City of Portland, Maine - Building or Use Permit Application
 389 Congress Street, 04101 Tel: (207) 874-8703, Fax: (207) 874-8716

Permit No: 02-1001	Issue Date: JUL 09 2003	CBL: 015 E007001
-----------------------	-----------------------------------	---------------------

Proposed Project Description:
Construct 3rd fl. Addition to include balcony, bedrm and bathrm

THIRD FLOOR PLAN

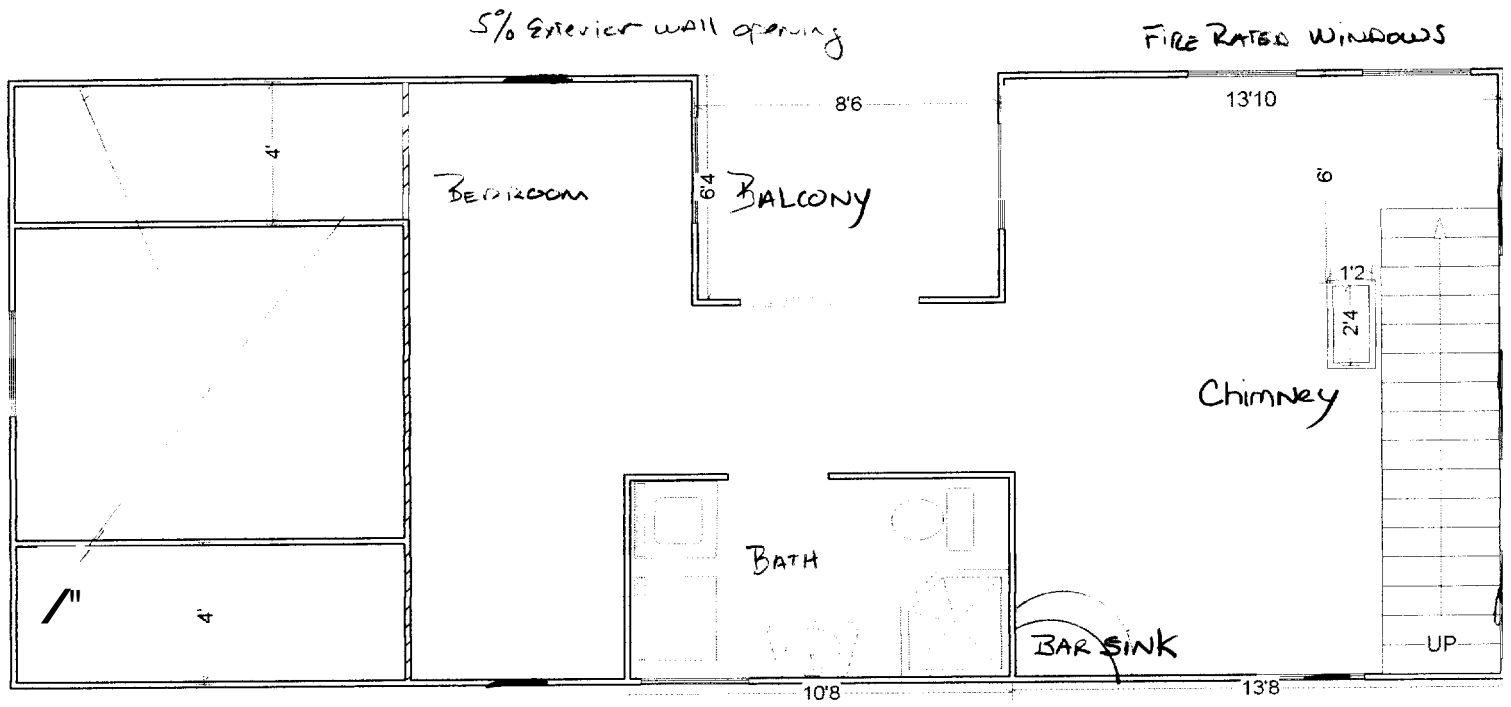
Note: 10/17/02 Spoke to Susan Link to verify information. The orientation of the building needs to be specified accurately. **Ok to Issue:**

The abutting building is within 5' . No fire separation is specified. Verified that the front 16' of attic roof line will remain the original pitch, no walls built.

- 1) The side windows on the balcony must be more than 3' from the property line to not require fire rating. The balcony doors do not have to be fire rated
- 2) Design specs on the operable 1 hour fire rated windows must be submitted to this office
- 3) Design load specs of the roof trusses must be submitted to this office
- 4) This permit was reviewed as Use Group R-4 using the ICC 1998 Code, which requires a 1 hour fire rating for up to 3ft. Of distance to the property line for 1& 2 family dwellings. The new dormer wall on the left side must be a 1 hour assembly with all windows rated 1hour.
- 5) Separate permits are required for any electrical or plumbing work.
- 6) Application approval based upon information provided by applicant. Any deviation from approved plans requires separate review and approval prior to work.
